Arun District Council
Arun Civic Centre
Maltravers Road
Littlehampton
West Sussex BN17 5LF
Planning & Building Control General Enquiries
Tel: (01903) 737756 Fax: (01903) 730442
Dx: 57406 Littlehampton
Minicom: 01903 732765
e-mail: planning@arun.gov.uk
website: www.arun.gov.uk/planning

Application No: AW/159/21/HH
Site Address: 25 The Drive Aldwick PO21 4DU
Description of works: Loft extension with 3 x rear dormers. This application affects the setting of the Craigwell House Conservation Area.

Thank you for your internet representation made on 22nd June 2021 which has been recorded as an objection with the comments as follows:

Drawing Title  
Proposed Plans & Elevations

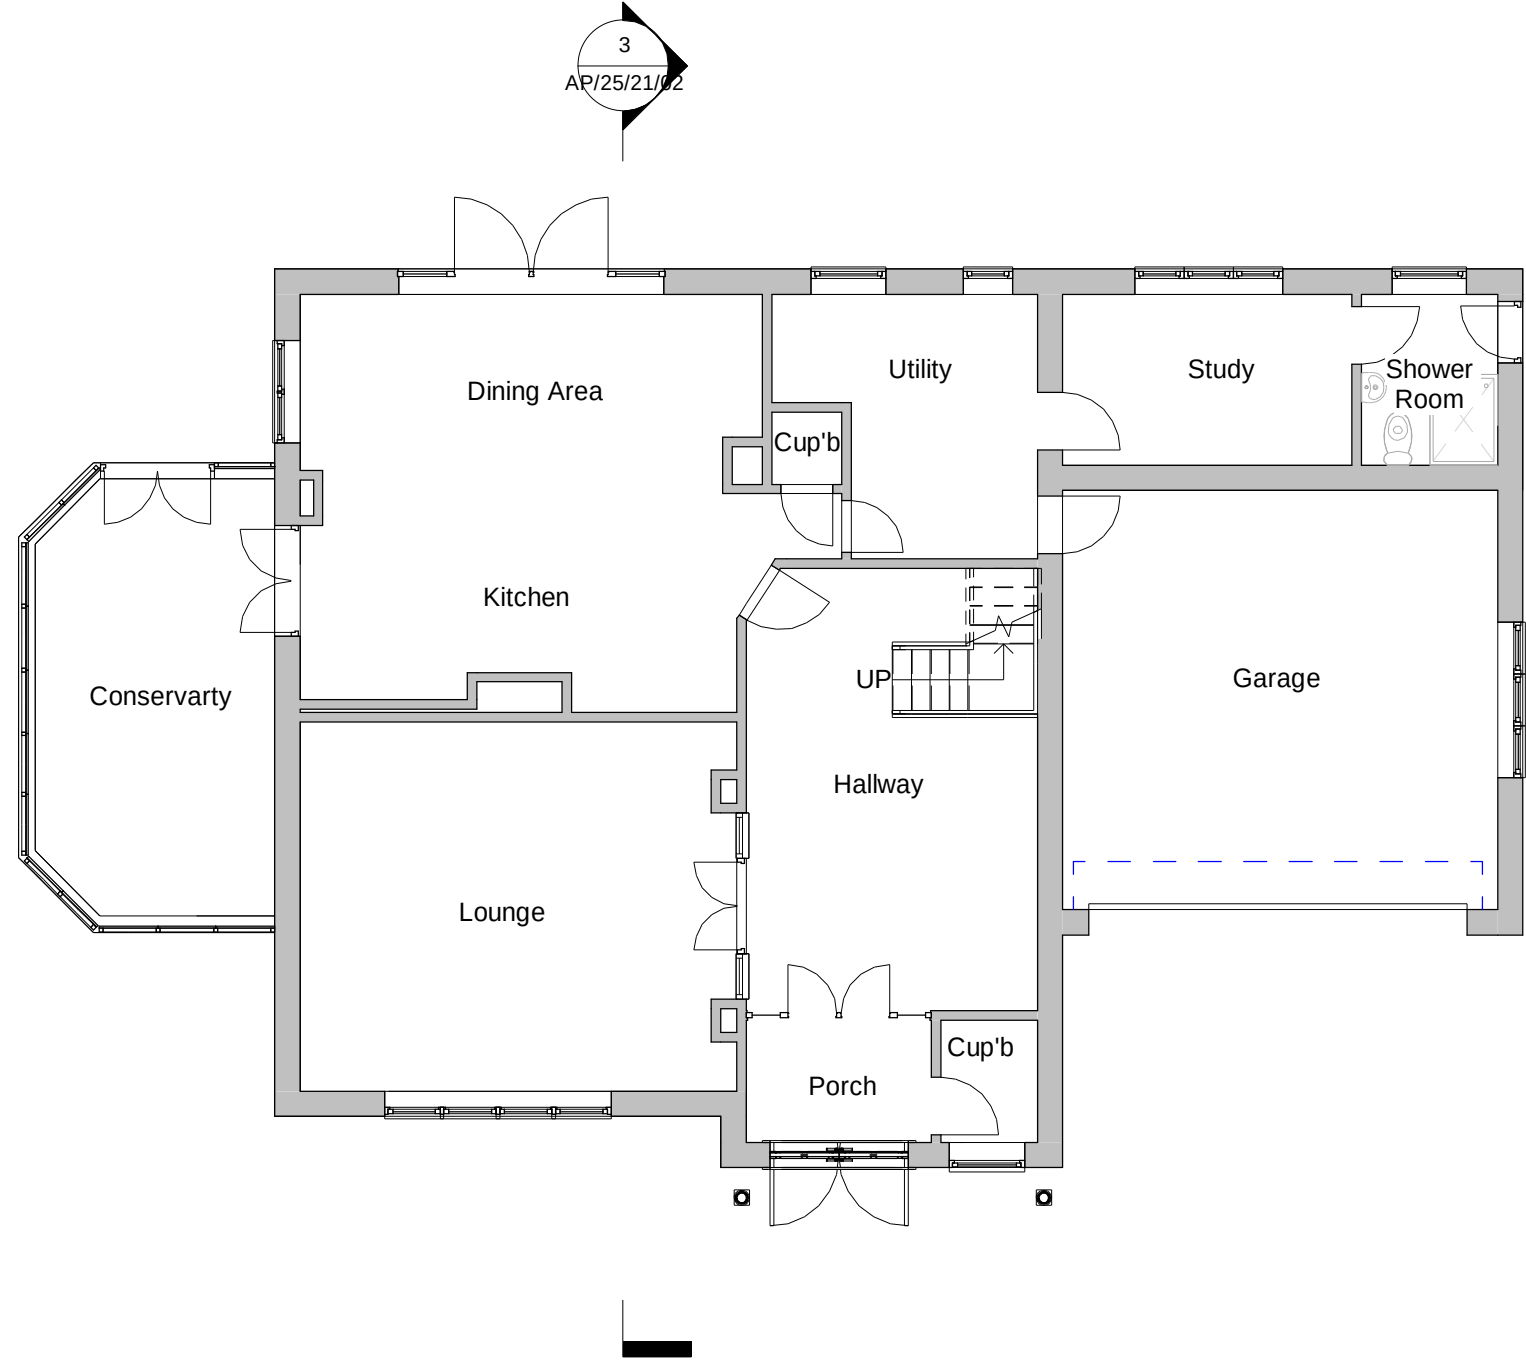
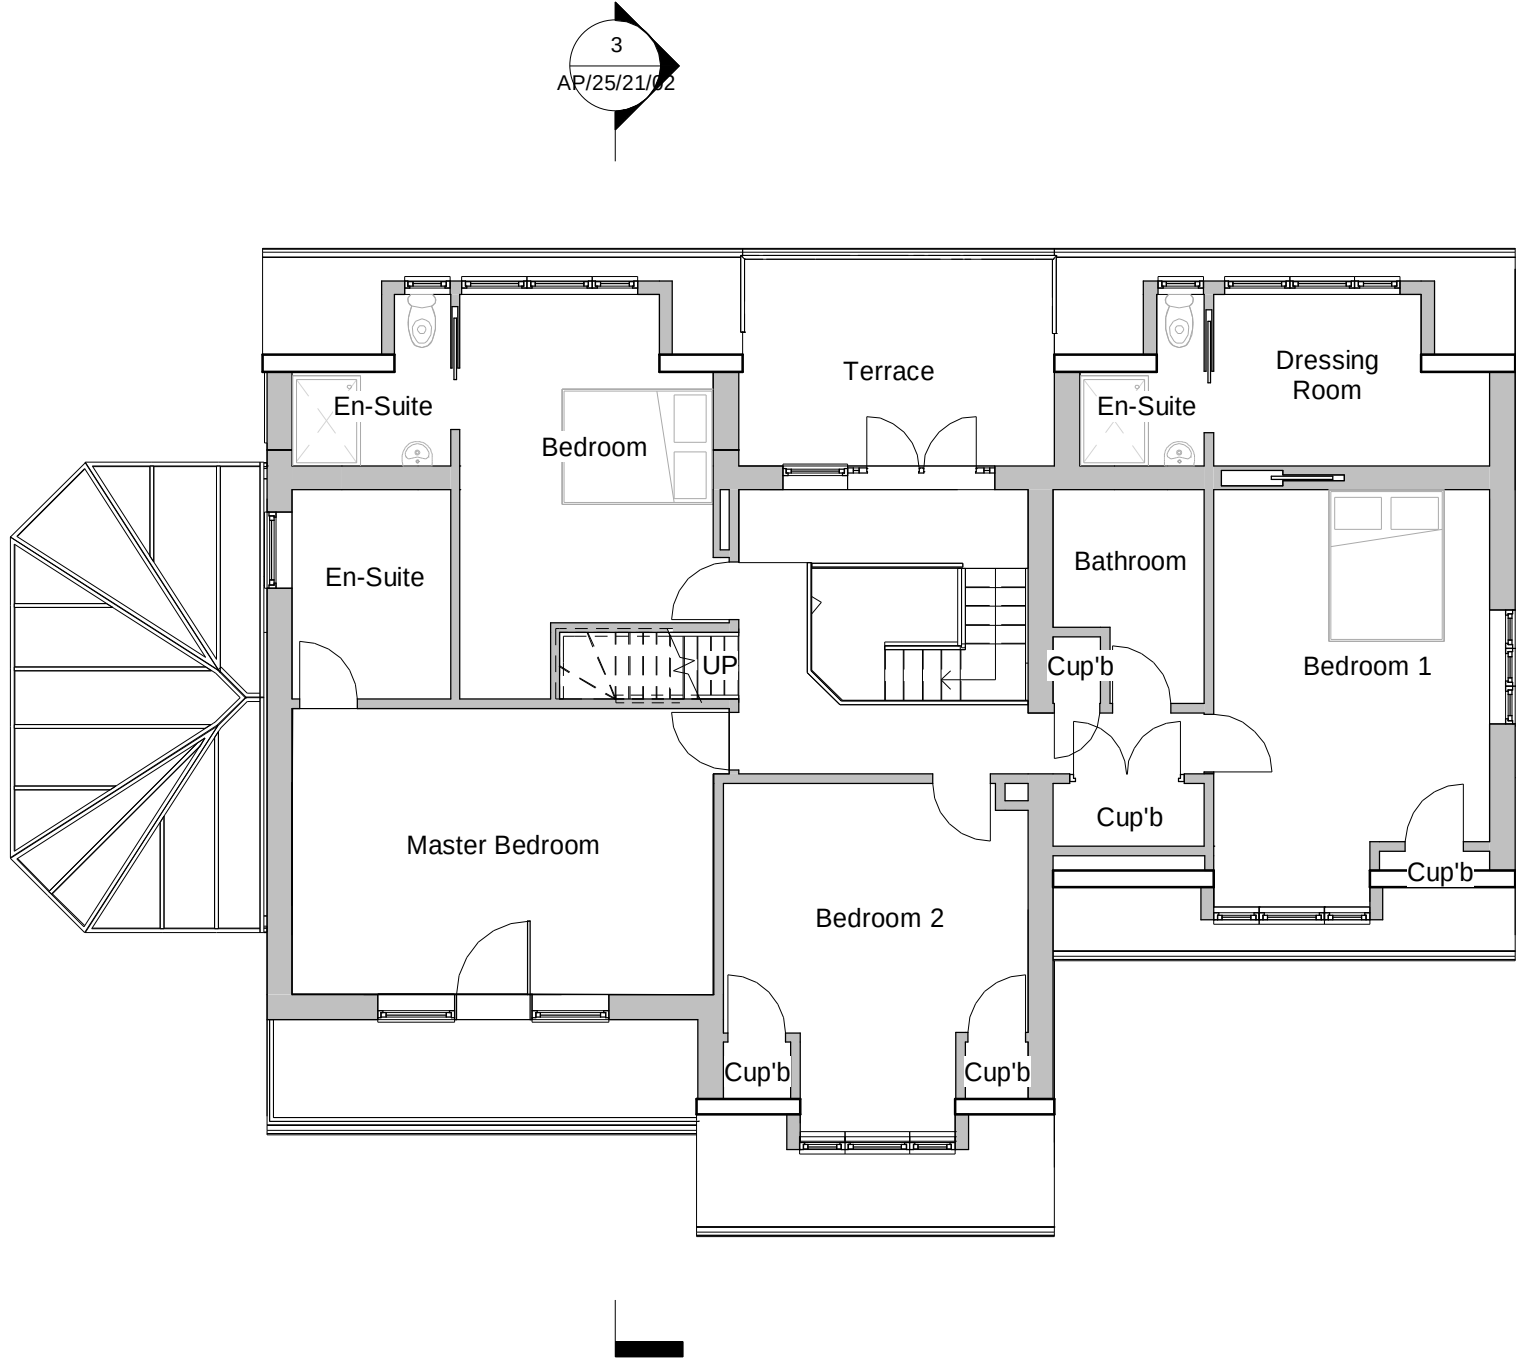
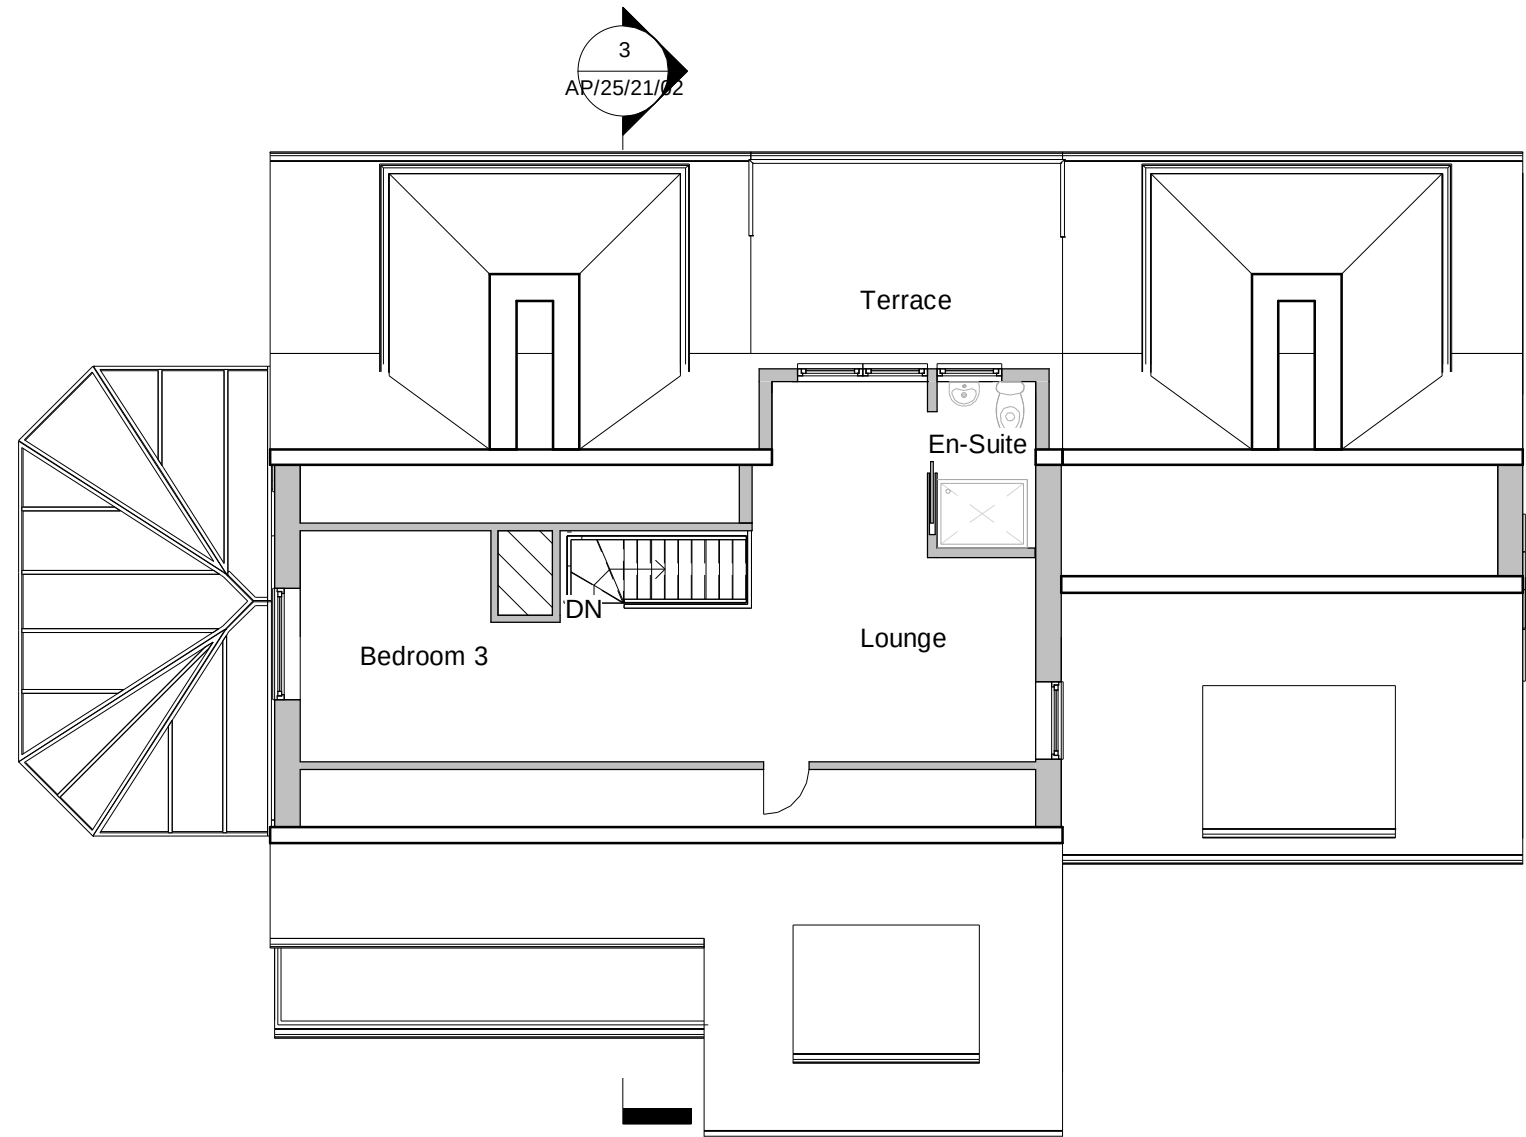
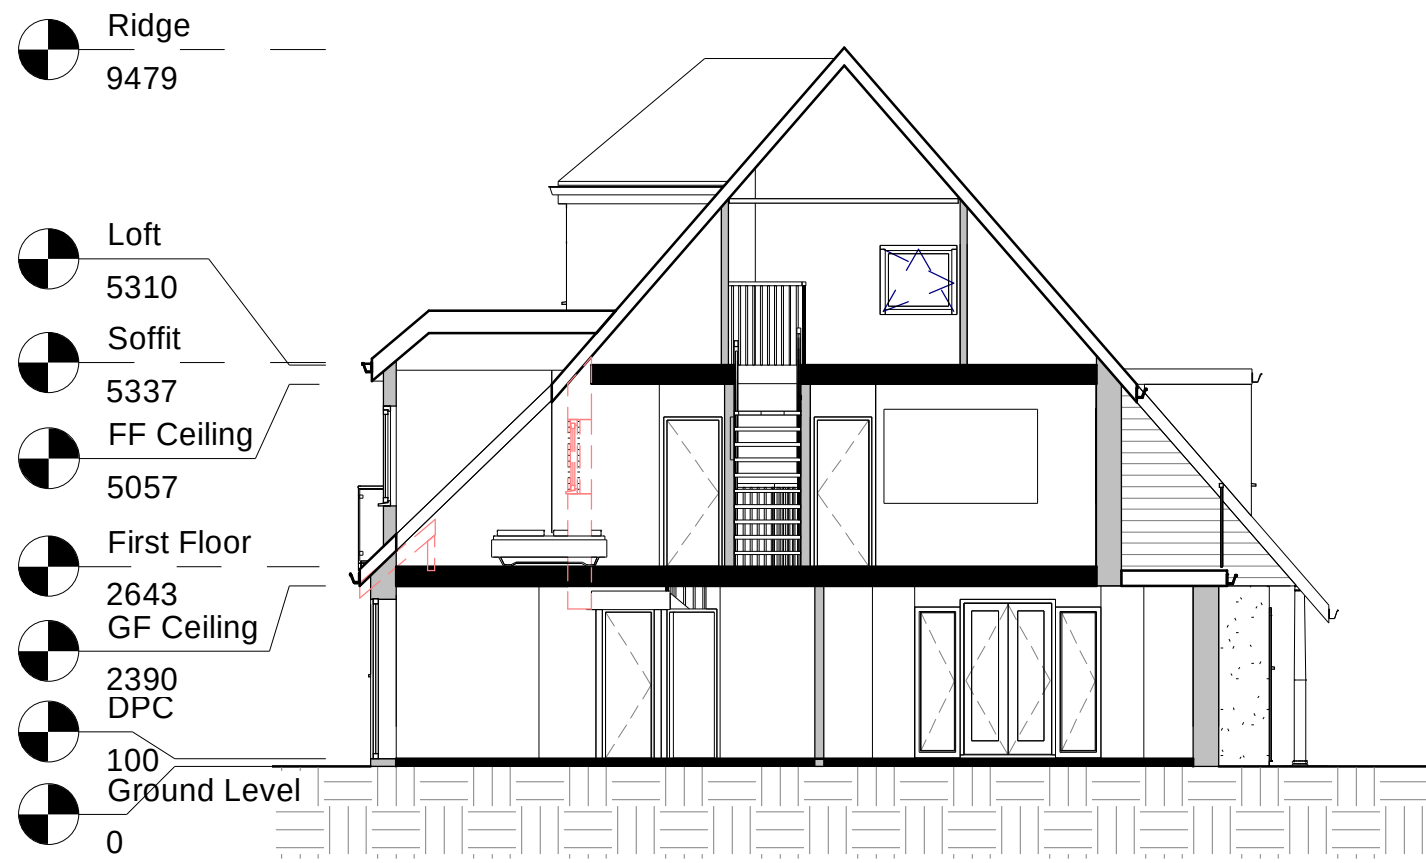
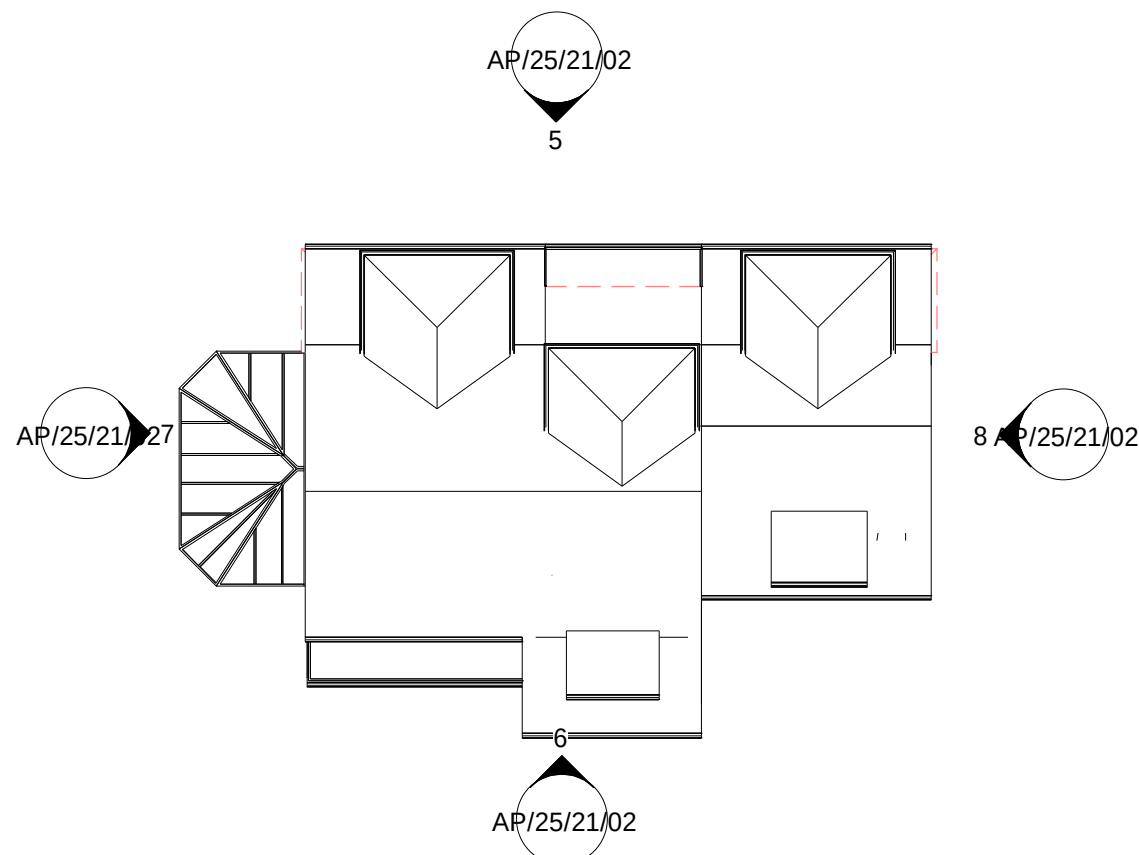
If this is a planning condition within a conservation area, why would residents who live within a conservation area, but who are looking at the rear elevation of a house be subjected to a carbuncle of an extension at loft level. Prince Charles when commenting on the proposed extension to the National Gallery indicated that it would be a carbuncle, much as this domineering proposal is within the conservation area that we live.

I understand that a high quality design that enhances and preserves the local area is required when considering the planning application within a conservation area, this design neither enhances or preserves the local environment.

I object to this planning application both on grounds of privacy as previously stated and that it will impact our enjoyment of a conservation area within a private estate.
